COUNTY COUNCIL'S RESPONSE TO CONSULTATION ON THE FOLLOWING DEVELOPMENT PROPOSAL

Application No: 18/00825/HYBRID

Proposal: Demolition of buildings and structures as listed in Schedule 1; Outline planning permission for up to 1,175 new dwellings (Class C3); 60 close care dwellings (Class C2/C3); 929 m² of retail (Class A1); 670 m² comprising a new medical centre (Class D1); 35,175 m² of new employment buildings, (comprising up to 6,330 m² Class B1a, 13,635 m² B1b/c, 9,250 m² Class B2, and 5,960 m² B8); 2.4 ha site for a new school (Class D1); 925 m² of community use buildings (Class D2); and 515 m² of indoor sports, if provided on-site (Class D2); 30m in height observation tower with zip-wire with ancillary visitor facilities of up to 100 m² (Class D1/A1/A3); 1,000 m² energy facility/infrastructure with a stack height of up to 24m (sui generis); 2,520 m² additional education facilities (buildings and associated external infrastructure) at Buildings 73, 74 and 583 for education use (Class D1); creation of areas of Open Space, Sports Facilities, Public Park and other green infrastructure; Change of Use of the following buildings and areas: Buildings 357 and 370 for office use (Class

KEY:	
	Shuttle Service to Heyford Station
	Oxford Service
	Bicester Service

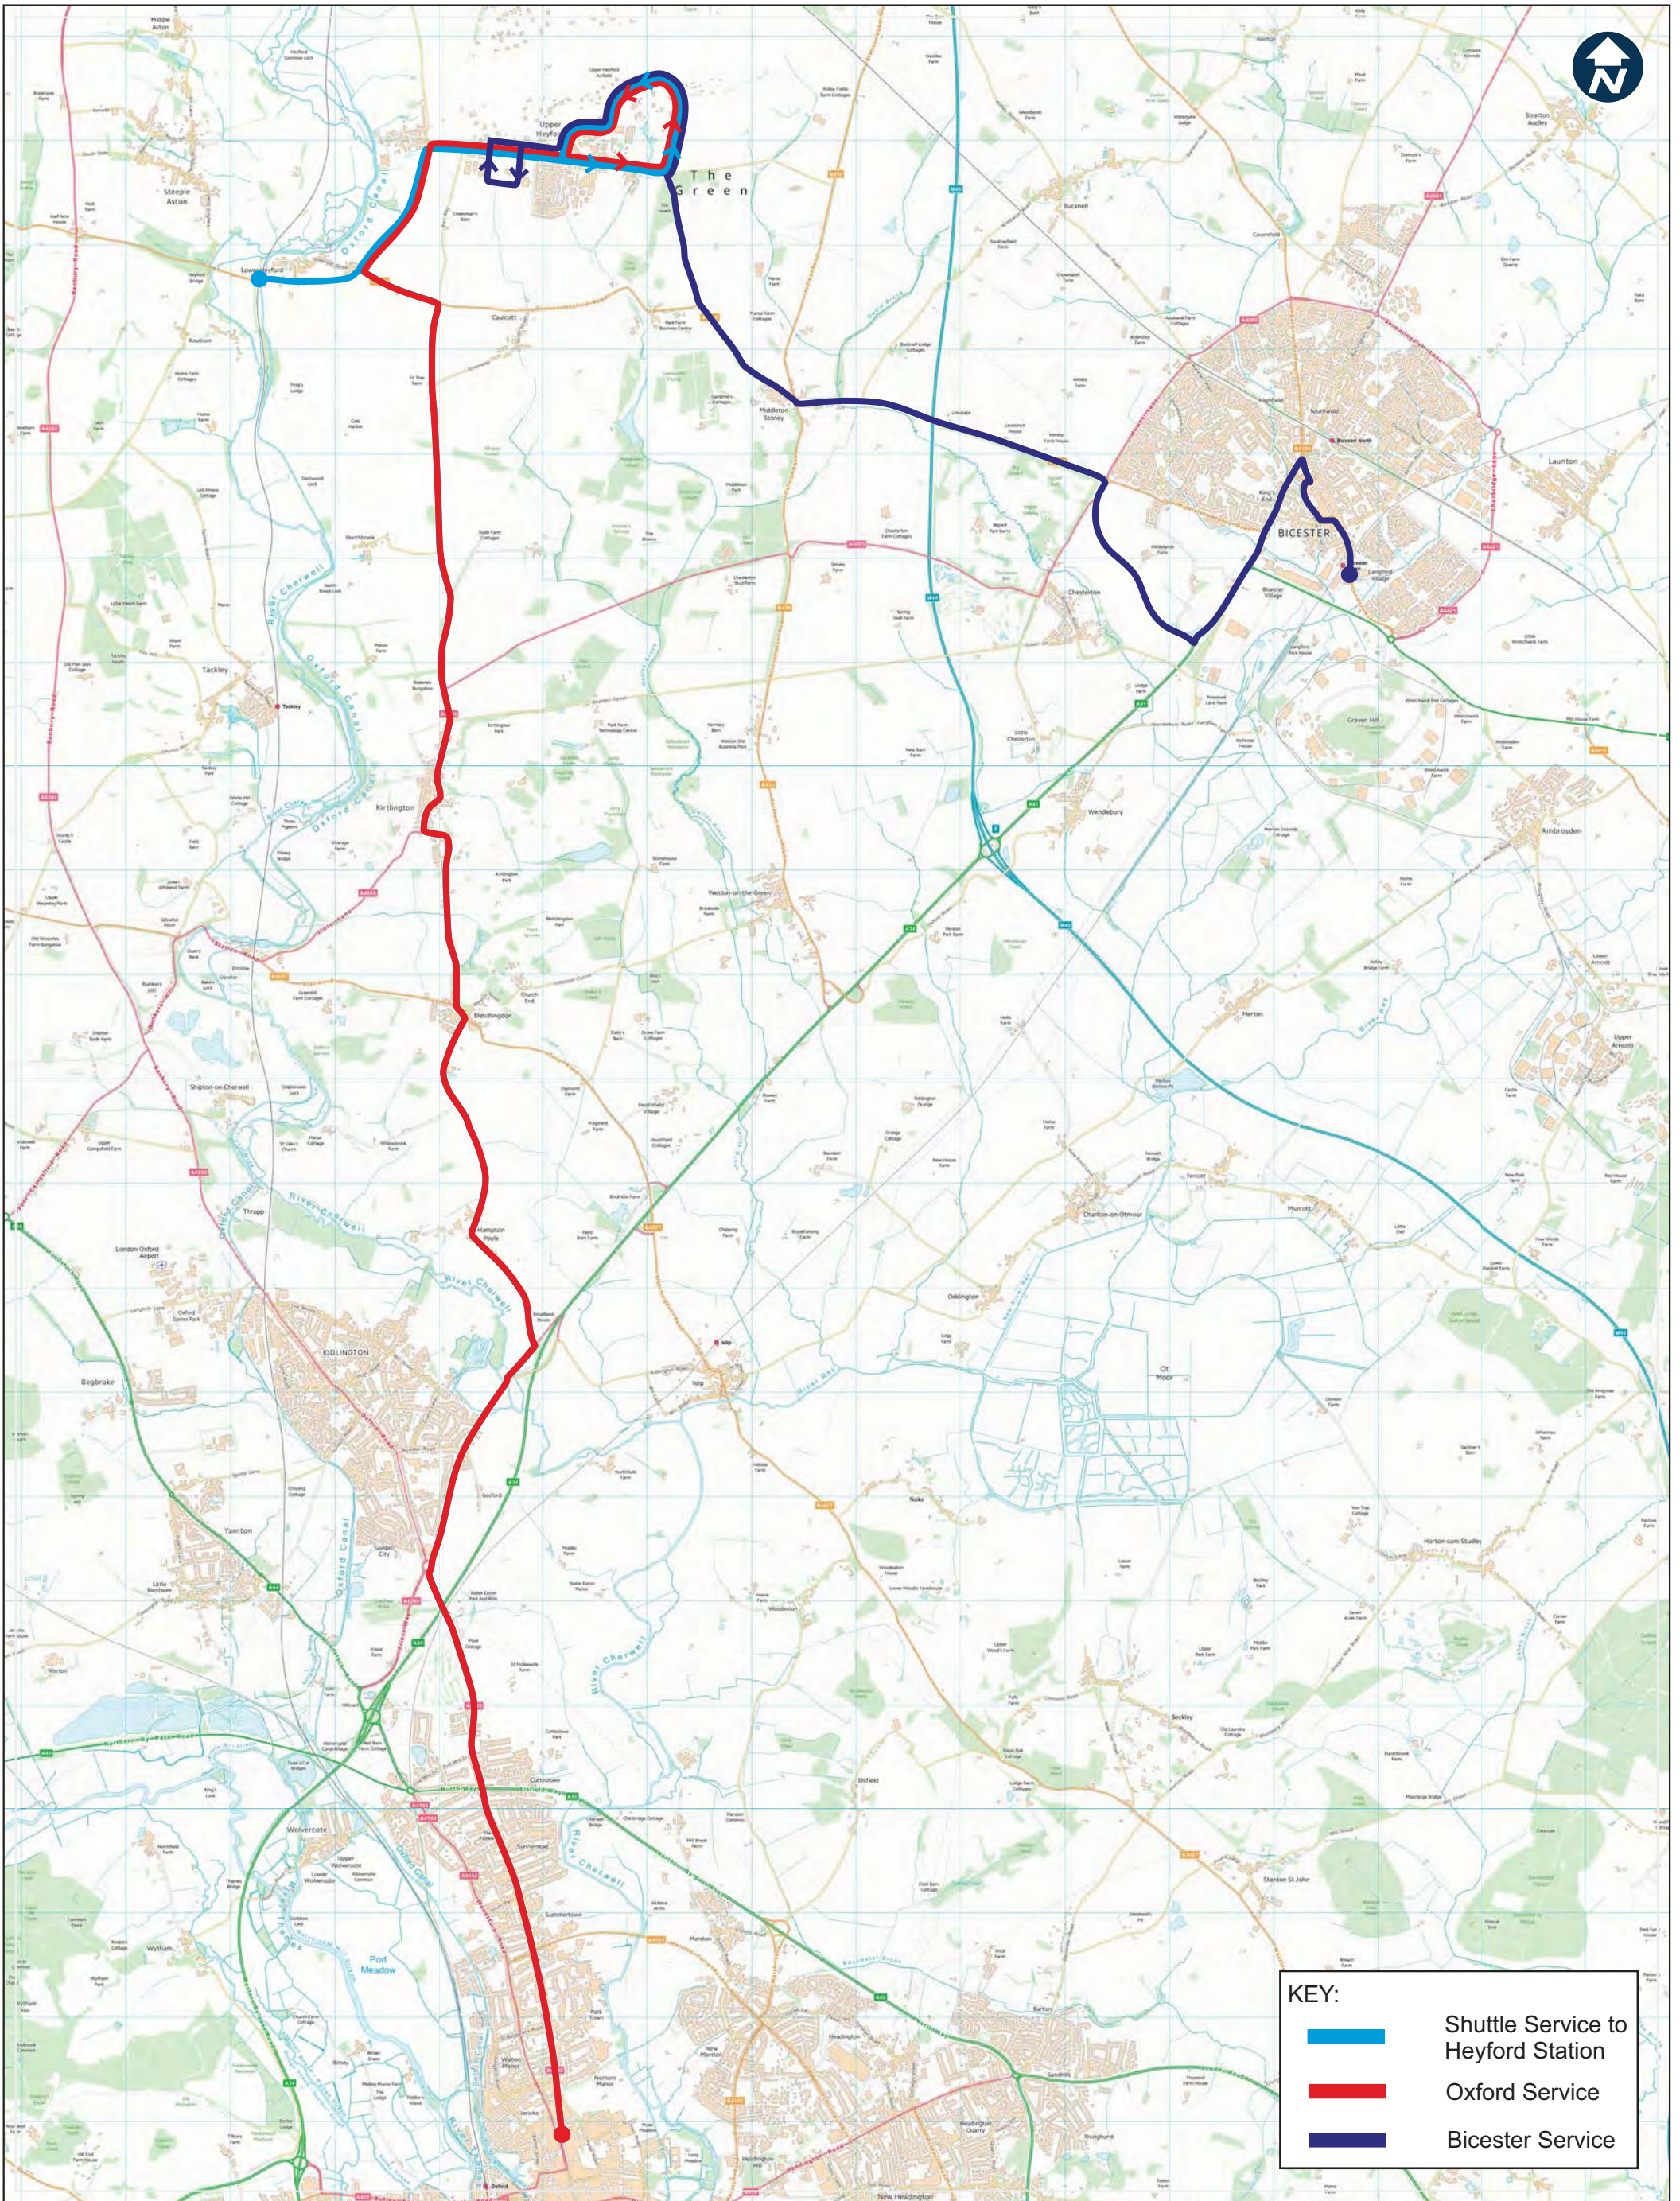
A supplementary minibus service is proposed, to provide a link from the development to Heyford station, to connect with trains and also to provide a service around the flying field. Details of how such a service would be specified and procured have not been provided. There is a significant concern that such a service would never be commercially viable and would require ongoing financial support. It is possible that a lower-cost operating arrangement could be found, but this is not certain. It is suggested that such a service could cost £100,000 per annum to operate, given the long operating day to meet early morning and evening trains. As a consequence of this uncertainty, it is suggested that provision is made for £1.0 million to secure the operation of this service for at least 10 years.

The bus turning arrangement at the western end of Camp Road needs to be revised, ideally through localised widening of Camp Road, provision of mini-roundabout and then layby on northern side, accommodating the bus stop. Penetration of the residential neighbourhood should be avoided, due to the substandard design of these roads for buses.

An additional pair of bus stops is required on Chilgrove Drive, adjacent to the proposed 2.5Ha commercial site, to provide accessibility to this part of the site. Two temporary bus stops will be needed on the south side of the eastern end of Camp Road, to provide access until the Chilgrove Drive route is fully available. It may be necessary to continue through operation of the current 250 service between Oxford and Bicester, until the north-east loop becomes available, perhaps supplemented by an additional Bicester-Heyford service.
